Phone: 0300 123 6780
Email: Kathryn.Walsh@lancashire.gov.uk
Your ref: 3/2025/0093
Our ref: 3/2025/0093/HDC/KW
Date: 14 March 2025

Location: 1 2 3 Skirden Lodge Wigglesworth Road Slaidburn BD23 4SX
Proposal: Alterations to existing building with nil use to form a 2 bedroom dwelling with car parking, garden curtilage and hard and soft landscaping.
Grid Ref: 376433 455981

Summary

No objection subject to conditions

document date:
28/01/2025
document stage:
PLANNING
drawn by: RH
checked by: RH
sheet name:
Proposed Site Plan

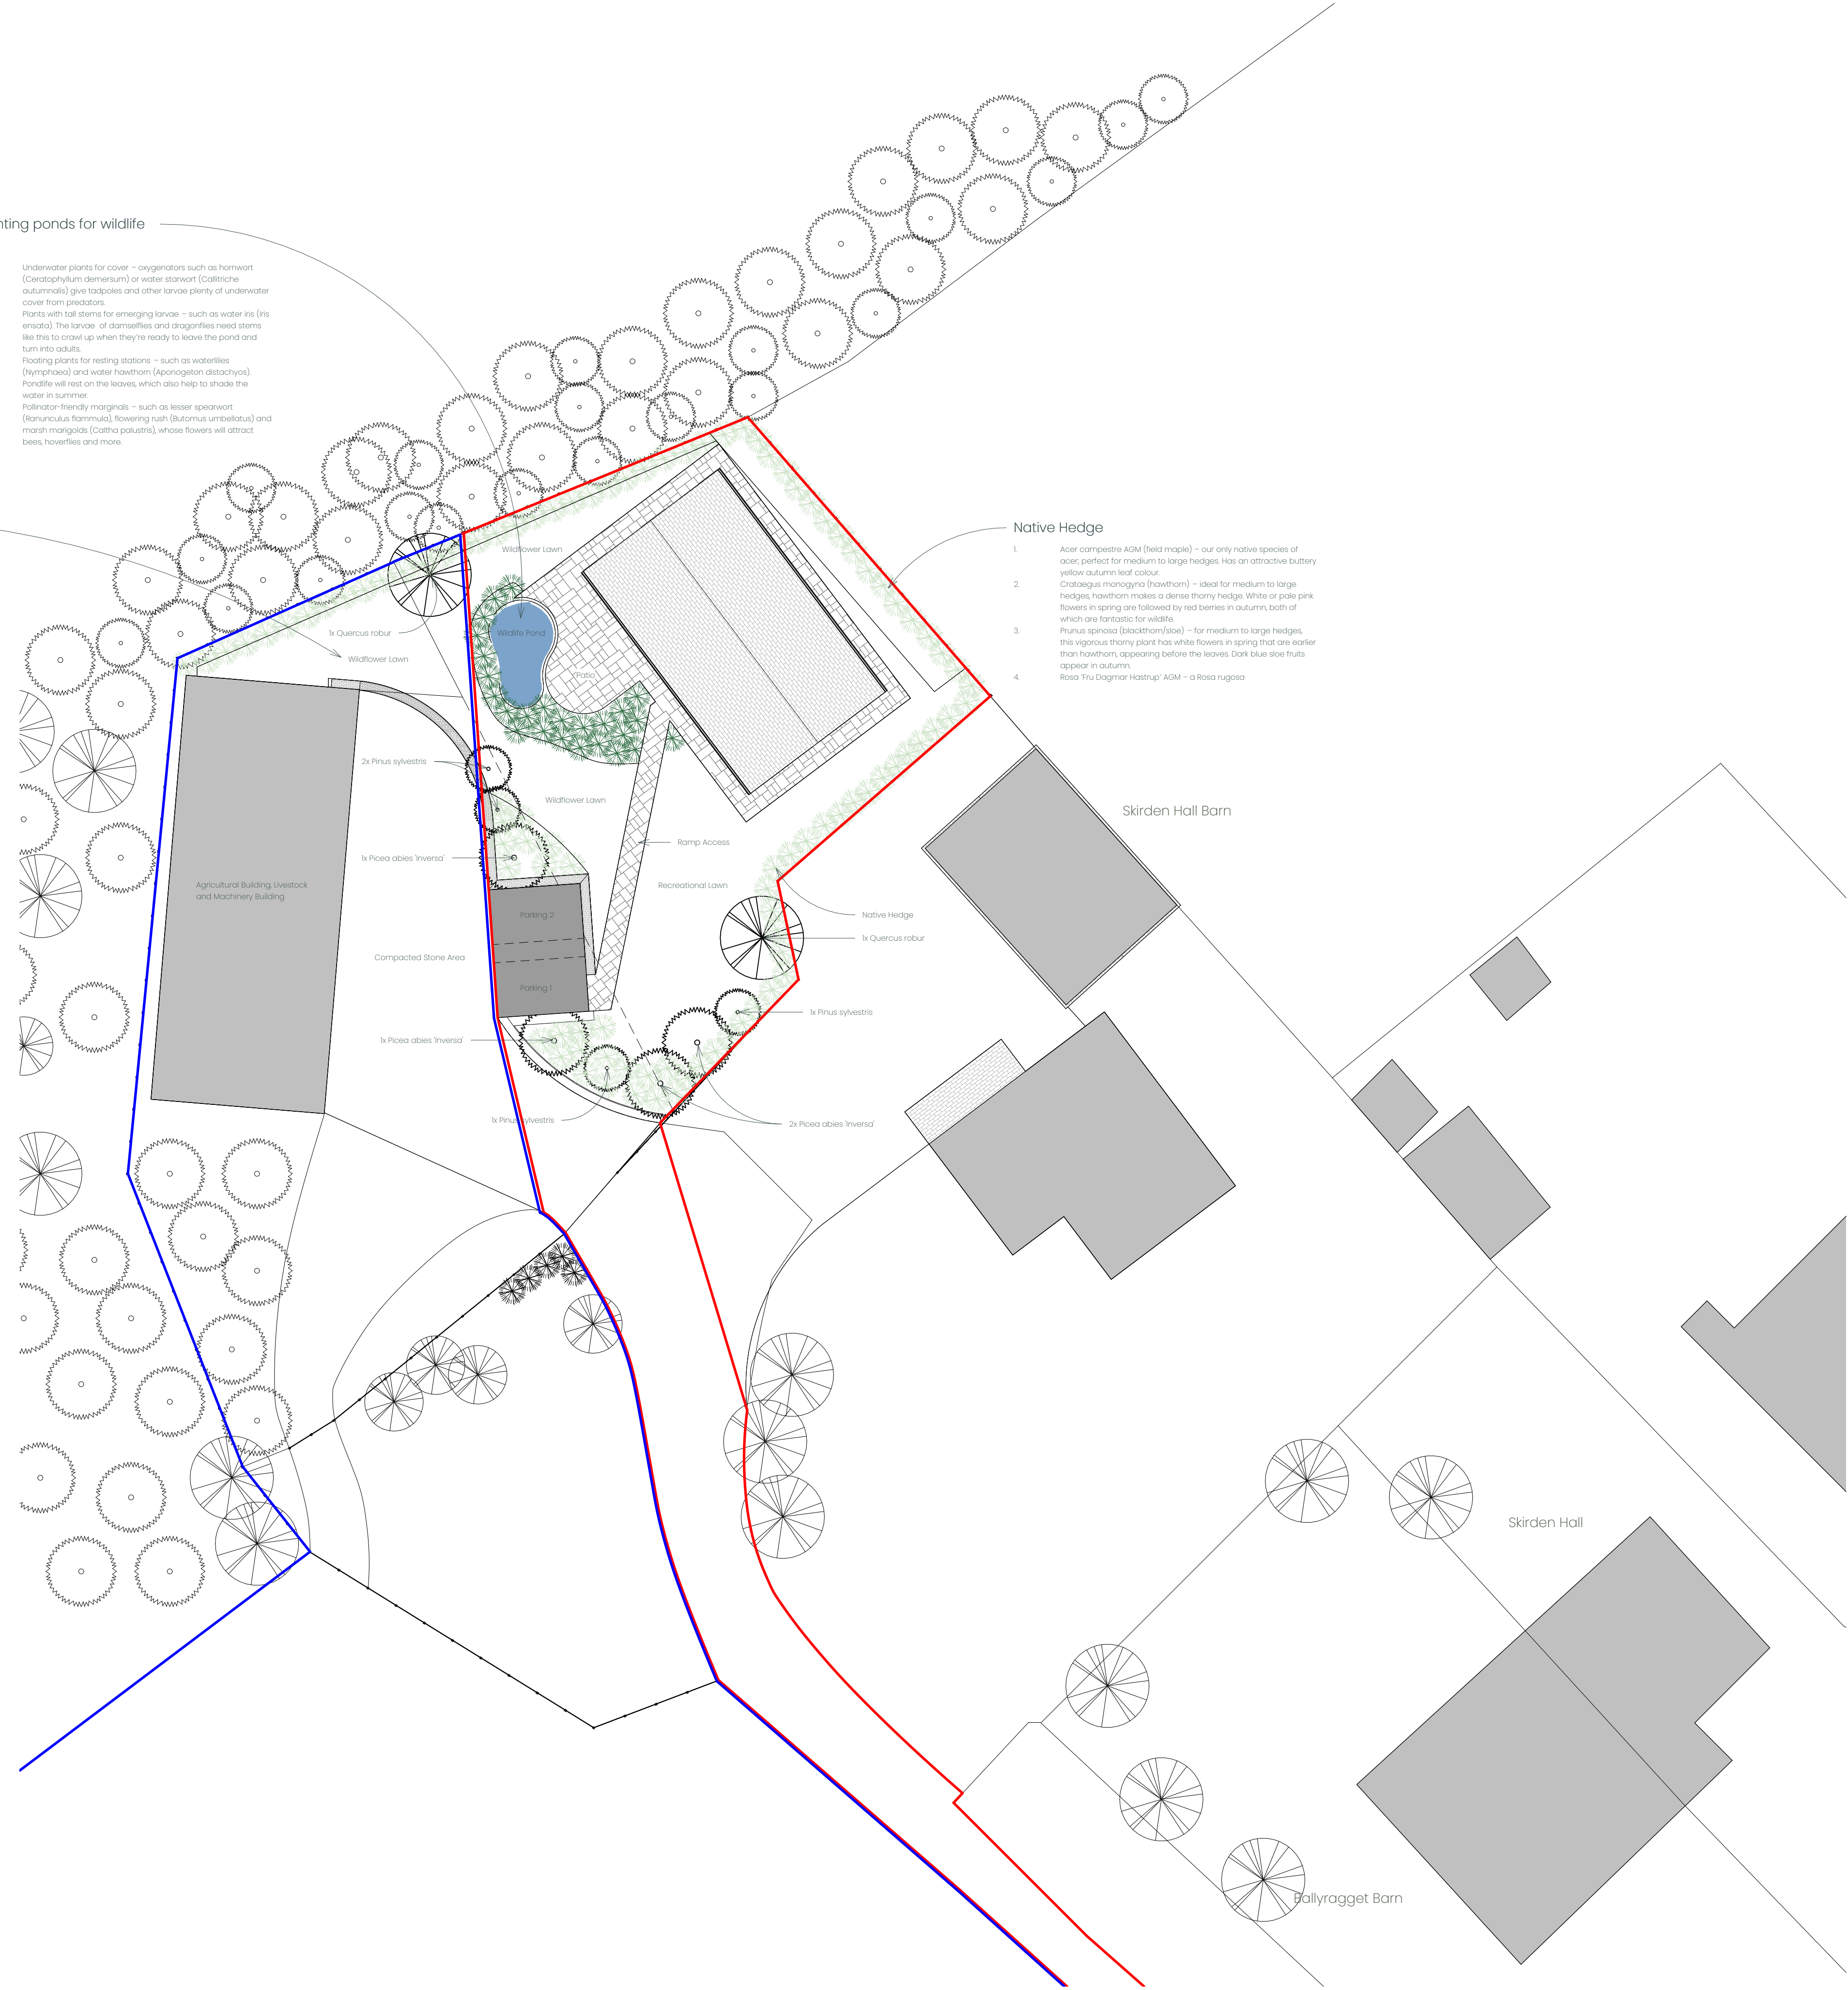
The LHA have reviewed drawing number A1.2 Rev1 titled Proposed Site Plan, and understands that the site will provide 2 car parking spaces for the development. This complies with the parking guidance found in the Joint Lancashire Structure Plan and so the LHA have no further comments to make.

1. The development hereby permitted shall not be occupied until such time as the parking and turning facilities have been implemented in accordance with the approved plans. Thereafter the onsite parking provision shall be so maintained in perpetuity.

2. The development hereby permitted shall not be occupied until such time as the access drive (and any turning space) has been surfaced with tarmacadam, or similar hard bound material (not loose aggregate) for a distance of at least 5 metres behind the highway boundary and, once provided, shall be so maintained in perpetuity.
